**RE: Responses to SHL23-036 SUB1 Review Letter**

Pump Station 10 Access Road Improvements Scope of Work

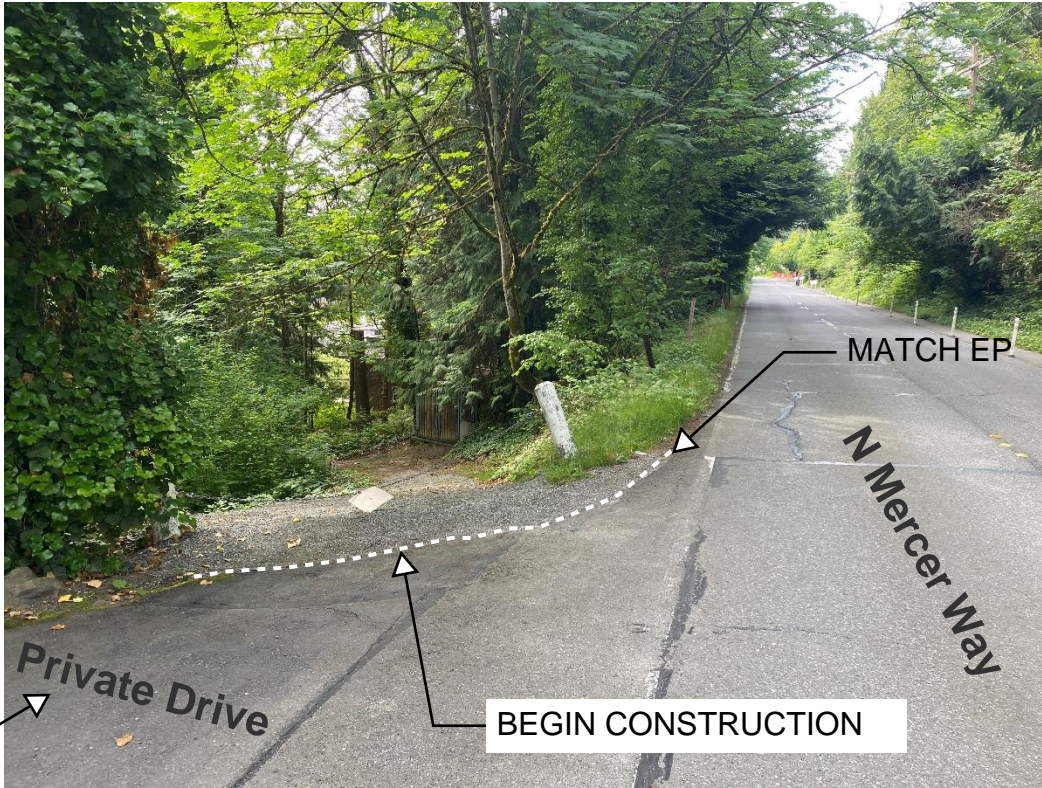
1. The total square footage of the new paving area.
  - Plans have been revised to include the proposed paving area = 1,990 SF.
2. A cross section of the new paving area.
  - Cross-sectional details A, B, and C for improvements over existing access road gravel, concrete, and gravel/native mix, respectively, have been added to the revised plans.
